**WELWYN HATFIELD BOROUGH COUNCIL
EXECUTIVE DIRECTOR - PLANNING, PUBLIC PROTECTION AND GOVERNANCE**

Application No: 6/2020/2592/FULL
Location: 22 Cornflower Way Hatfield AL10 9FY
Proposal: Change of use of amenity land to residential land, erection of outbuilding (garden room) and fencing.
Officer: Mr David Elmore

Recommendation: Refused

Drawing No: 5099-P01 Revision: A

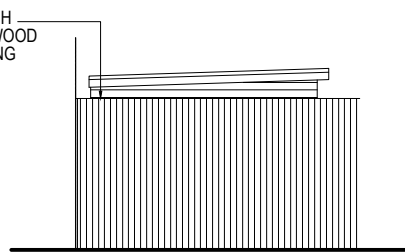
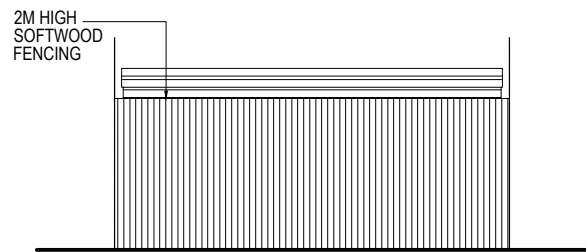
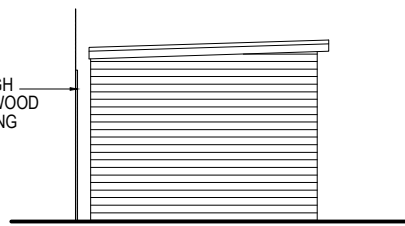
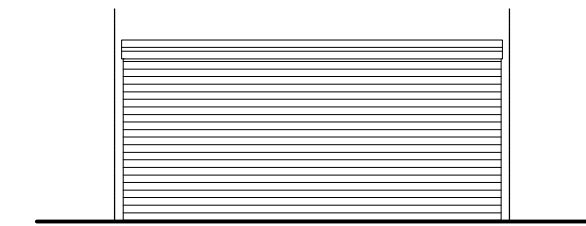
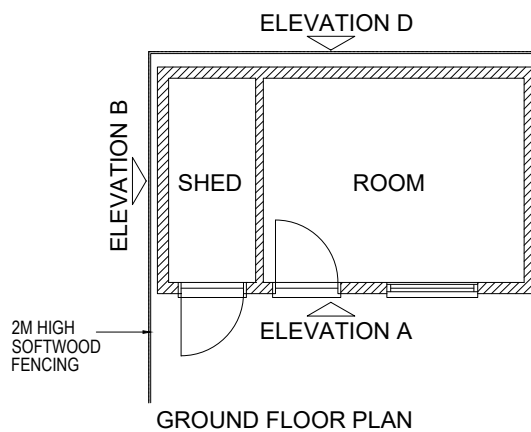
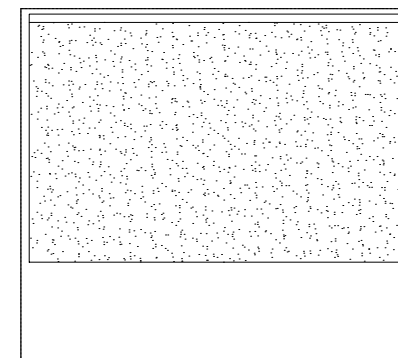
The development would severely detract from the character and appearance of the area, including its landscape setting. It would represent a poor standard of design and conflict with Policies D1, D2 and D8 of the Welwyn Hatfield District Plan 2005, the Council’s Supplementary Design Guidance 2005 and the National Planning Policy Framework.

The development would fail to contribute to and enhance the natural and local environment by minimising impacts on and providing net gains for biodiversity. Consequently, the development would conflict with Policy R11 of the Welwyn Hatfield District Plan 2005 and the National Planning Policy Framework.
